Applicant: A2Dominion

Proposal: Partial discharge of conditions 13 (positioning of bicycle and bin stores), 24 (design and construction details), 31 (landscape design), 53 (site levels) and 84 (ecological construction method statement) (Infrastructure Phase) of 10/01780/HYBRID

Title
PROPOSED GENERAL ARRANGEMENT

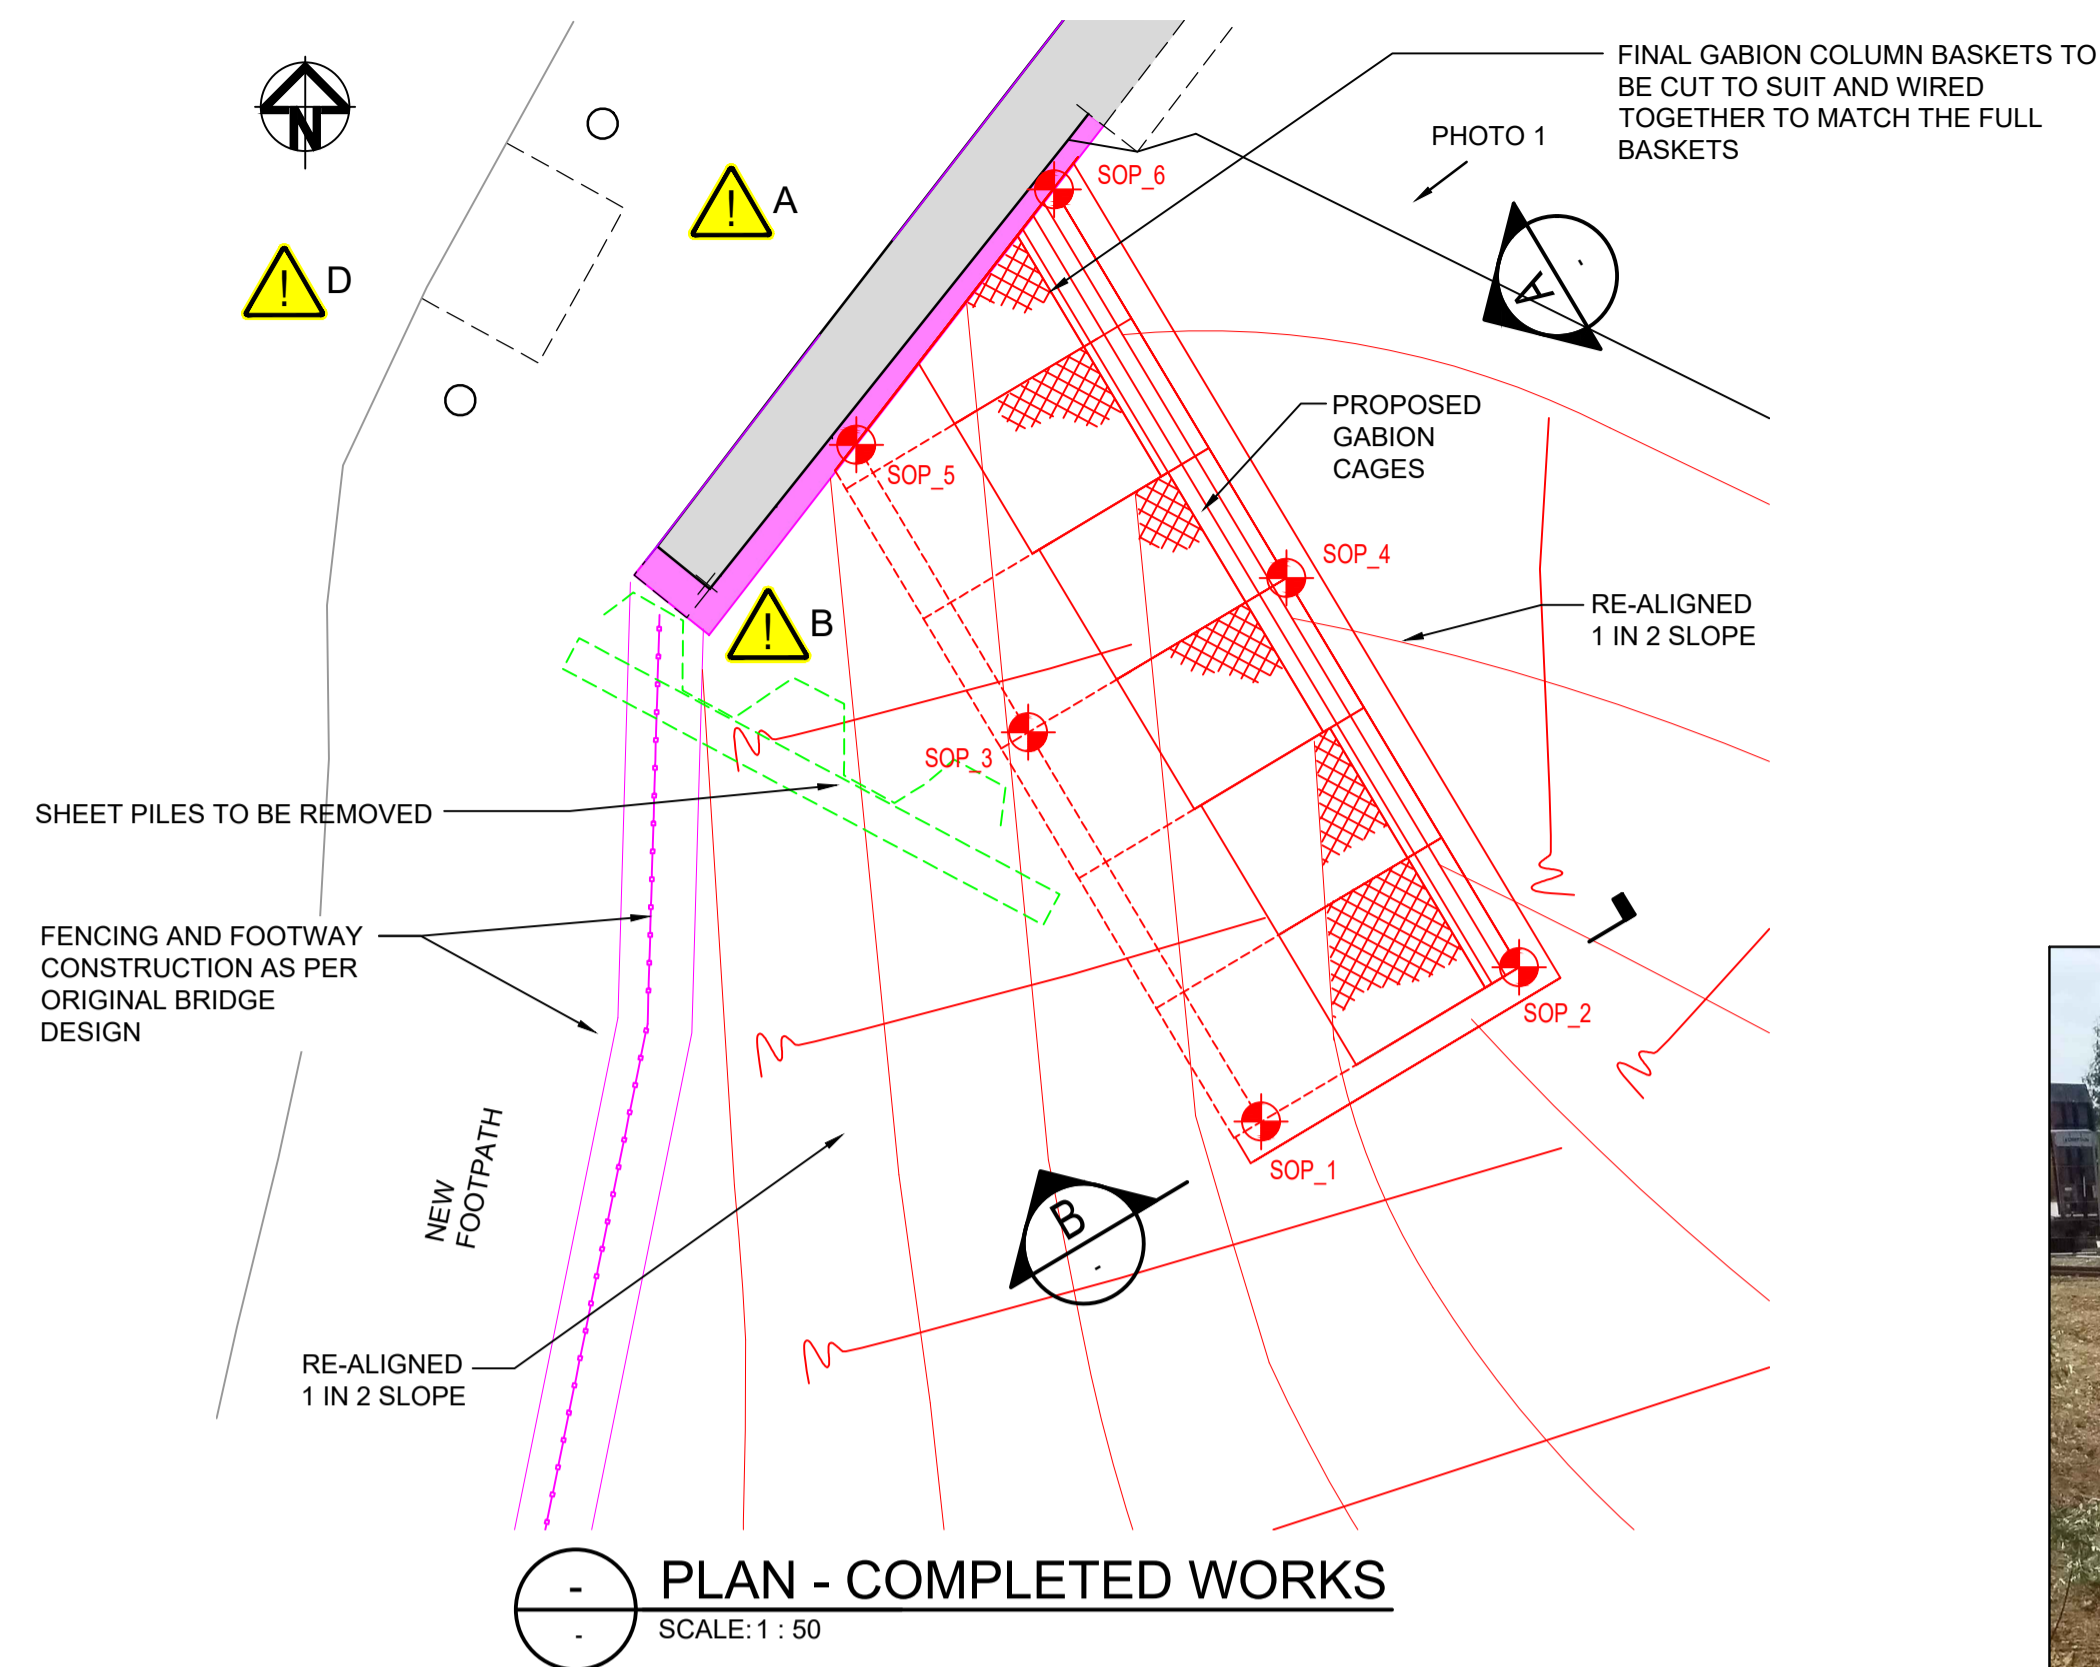
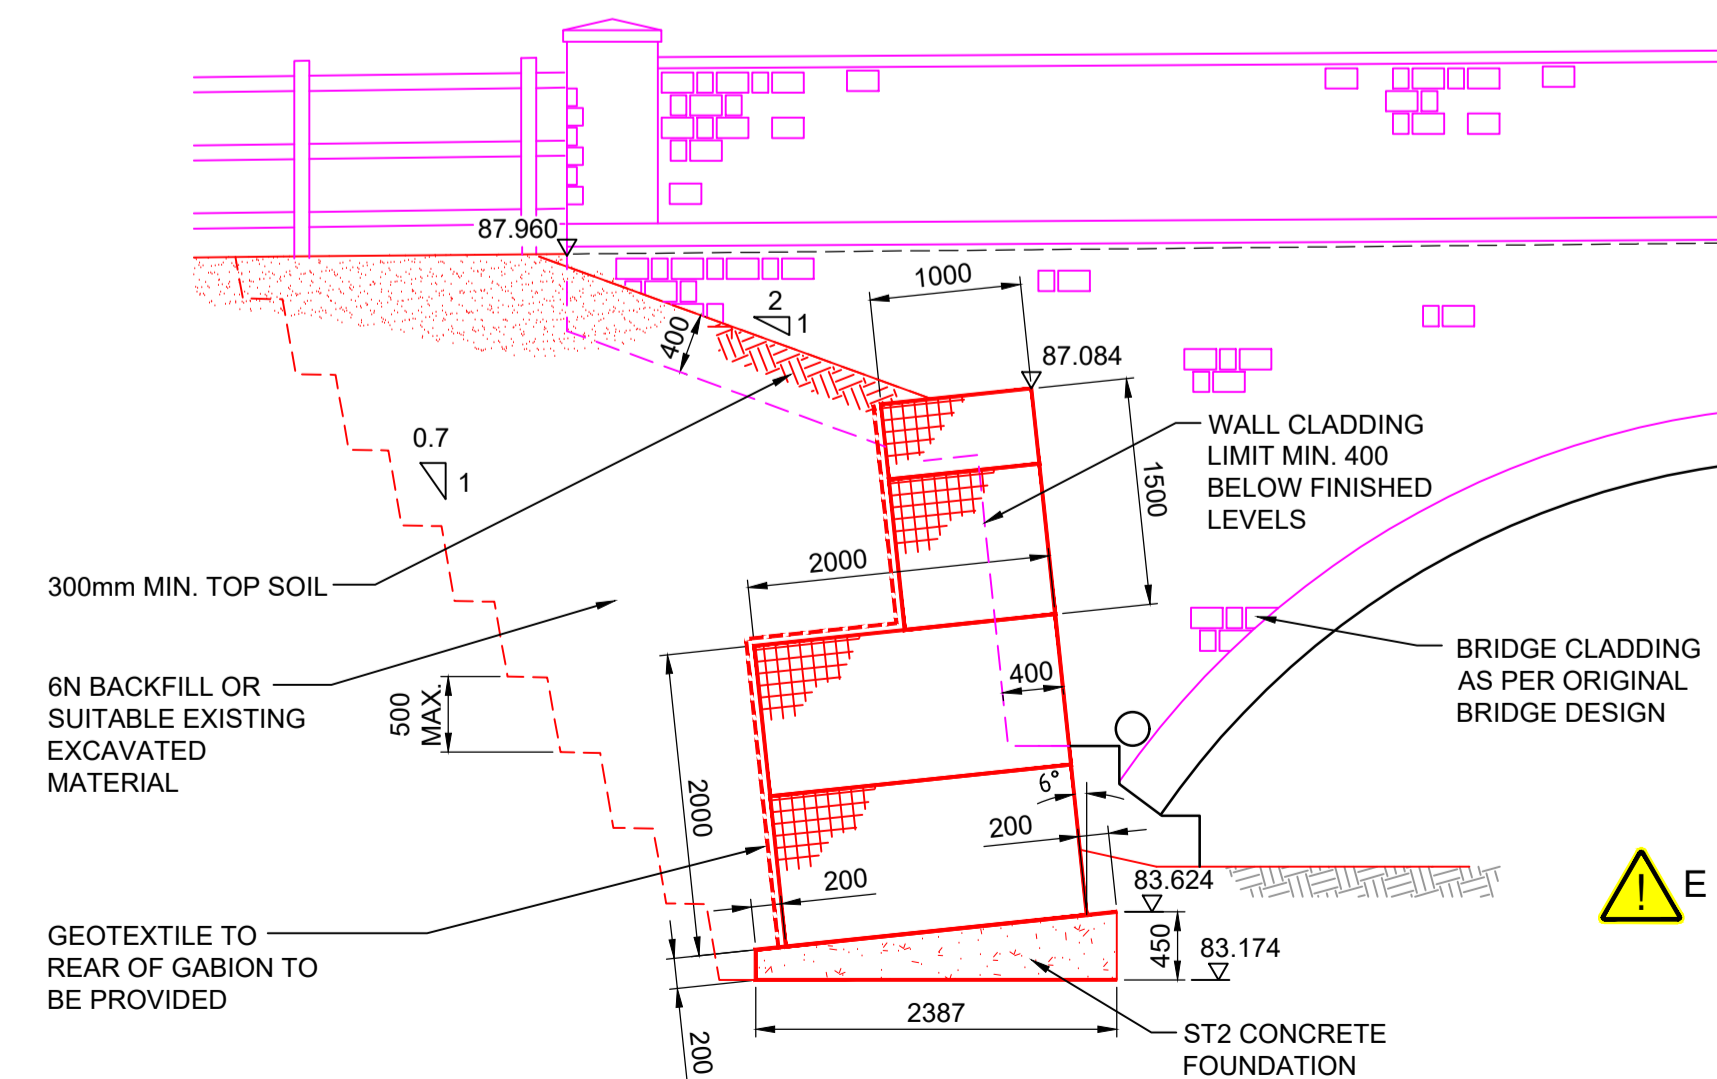
4.3 OCC BRIDGES TEAM: An Approval in Principle will be required for the retaining wall. There are some detailed concerns around fencing close to the parapet of the bridge structure, of the safe bearing capacity of the existing ground at the founding level of the gabions (informed by a Geotechnical Investigation), the material proposed for the gabions, the need for pedestrian protection at the top of the gabions, for the potential need for plastic weep pipes to be installed to allow for water build up behind the wall to dissipate and the need for the wall design calculations and drawings for the technical approval process to be submitted. The Approval in Principle should be granted prior to a decision being issued through planning.

- 5.17. No comments were originally received in relation to this matter through the Consultation process however given that I am aware the OCC Bridges team have been involved in overseeing the construction of the bridges, I contacted the team to seek a response to the two detailed plans and a risk assessment. The advice received set out some detailed concerns, all of which related to technical matters relating to the construction of the gabions and their proximity to the bridge and the potential need for an approval in principle (sought before this was approved through planning). This is however a separate technical process and the approval of details to discharge conditions does not override the need to comply with and seek approval through technical approval processes (similar to the processes involved in seeking approval for highway works under the Highway Act). Upon providing the applicant's response to the points raised by OCC and querying matters, no further advice has been received from OCC. Should there be any changes that are required through a later approval process, then this could result in a need for a further application to re-discharge the condition depending upon what that change relates to. A planning note is recommended to remind the applicant that an approval in

The details of the proposed retaining structure to enable the cladding to the Northern highway bridge to be completed as shown on drawing numbers 500-001-10036317-01 titled 'Proposed General Arrangement' and 500-002-1036317-01 titled 'Embankment Stabilisation Construction Sequence', Health and Safety Designer's Risk Assessment document issue date 18/10/2019 and email from Barton Willmore dated 27/08/2019 confirming the Gabion Walls would be filled with locally sourced stone.

2. The applicant is advised that whilst the Local Planning Authority consider the details of the retaining structure to enable the cladding to the Northern highway bridge to be completed to be acceptable, a separate technical approval process may be required to be completed with Oxfordshire County Council as the Highway Authority and in respect of the bridge structure. The applicant is advised to contact Oxfordshire County Council regarding any necessary approvals prior to work commencing to ensure that technical approval is secured.
